WEST SUSSEX COUNTY COUNCIL CONSULTATION

TO:	Arun District Council FAO: Harry Chalk
FROM:	WSCC – Highways Authority
DATE:	5 March 2026
LOCATION:	Eastlands Littlehampton Road Ferring BN12 6PB
SUBJECT:	FG/10/26/PL Change of use from equestrian to secure dog exercising and associated development. This application is a Departure from the Development Plan and is in CIL Zone 3 (Zero Rated) as other development.
DATE OF SITE VISIT:	n/a
RECOMMENDATION:	Advice

PLAN SHOWING
PUBLIC FOOTPATH IN
RELATION TO
APPLICATION SITE

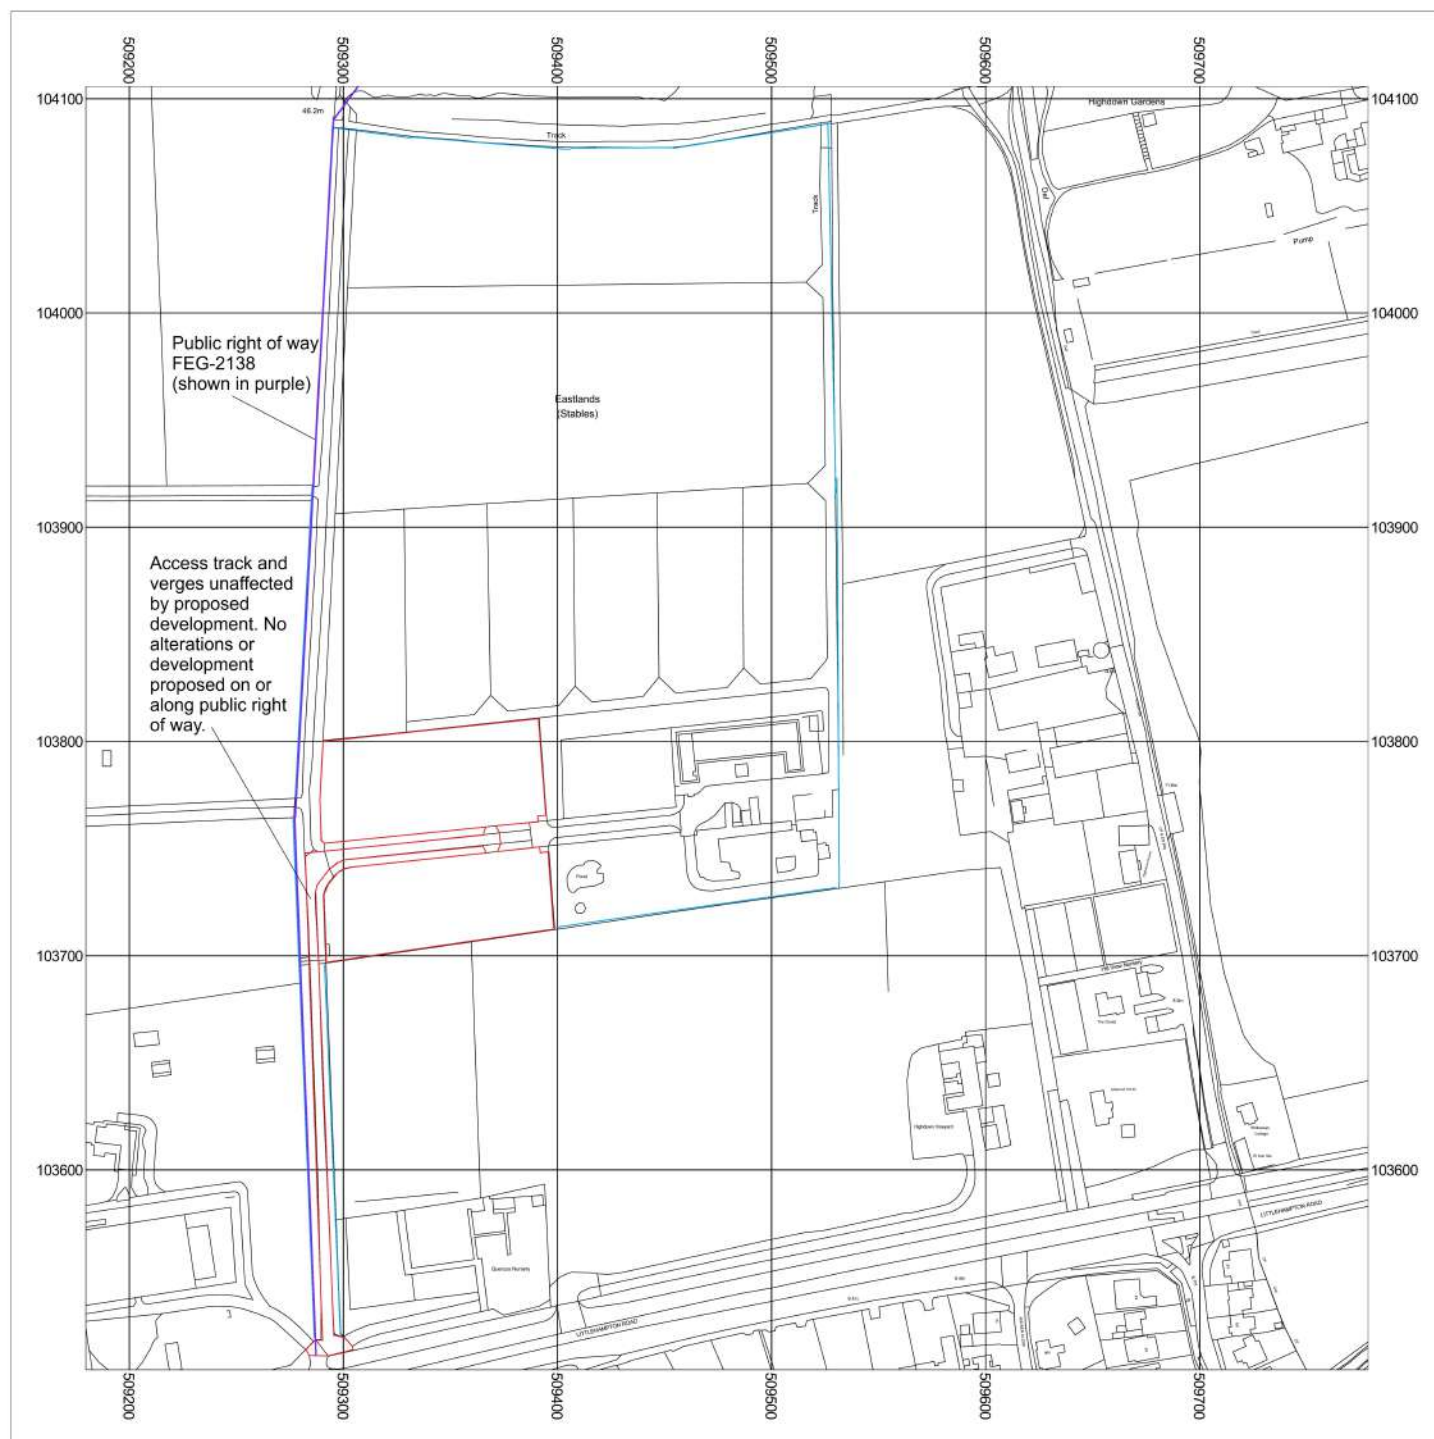
Any works proposed to the privately maintained road will be subject to formal approval from the road's proprietor. Part of the access road is also maintained as Footway no. FEG/2138/2 the LPA should therefore seek comments from the area PROW inspector regarding the proposals.
